KITITAS COUNTY

TO: All Staff
FROM: Kelee Hodges, Engineer Tech II on behalf of Justin Turnbull, County Surveyor
DATE: April 7, 2022
SUBJECT: County Survey Review of BL-22-00007 Luft

SHEET 1 OF 2

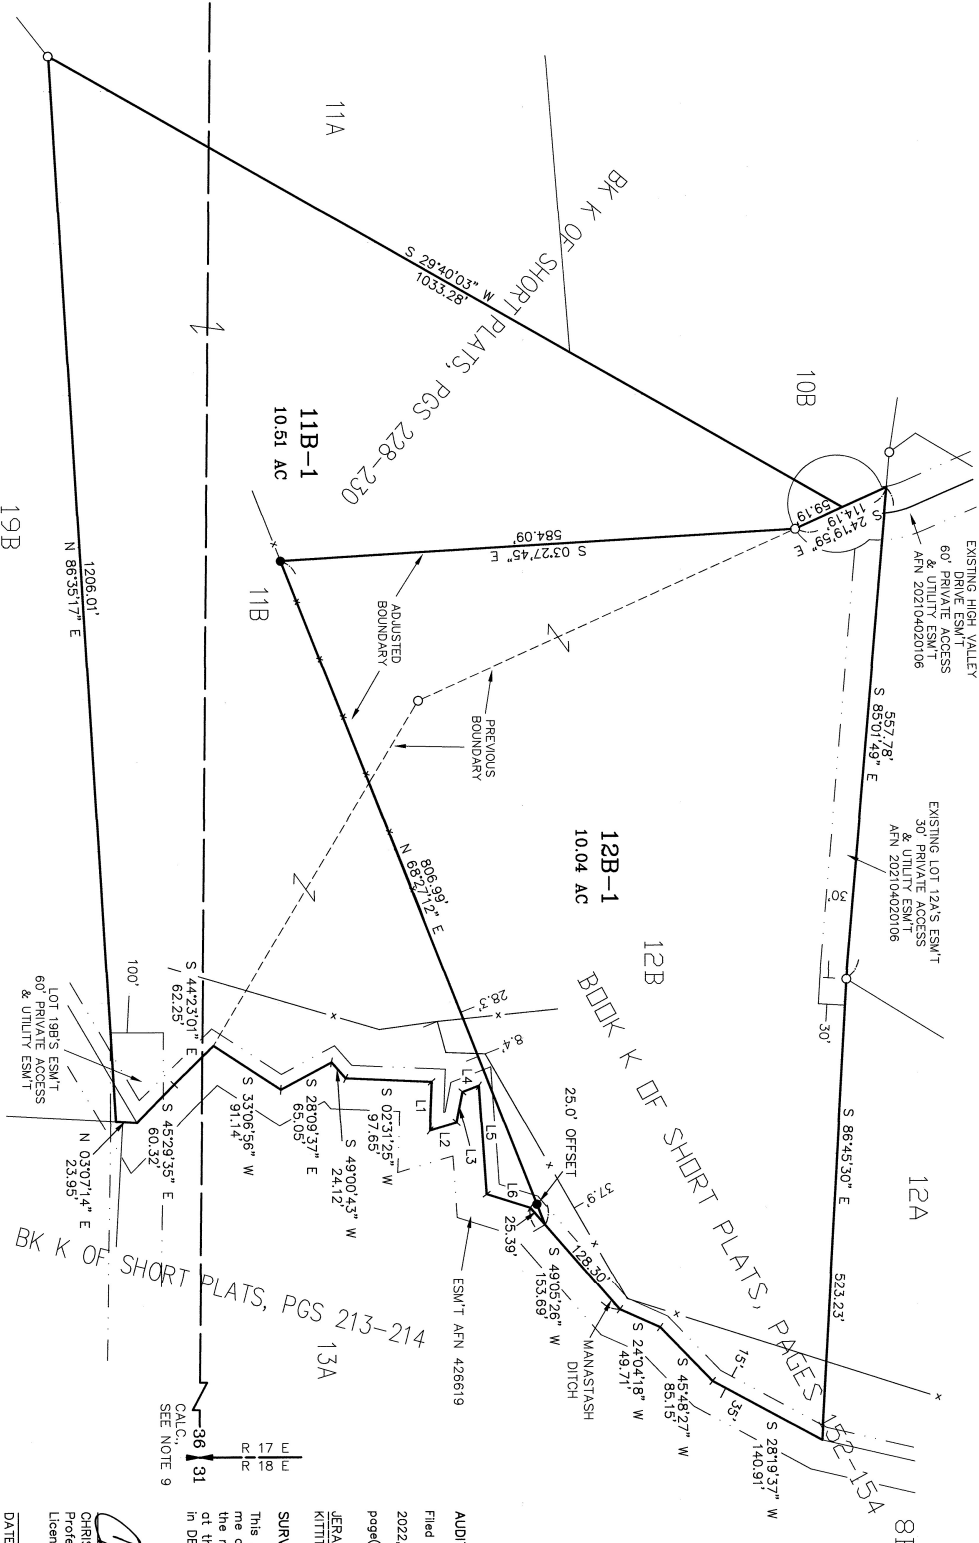
1. All easements must be labeled as "Existing", or "Created via separate document".
2. All existing easements must show the recording number, width, and type of easement.
3. All encroachments, usage lines, and trespasses shall be noted on the face of the survey, with a dimension to property boundaries. (WAC:332-130-050(1)(f)(vii))
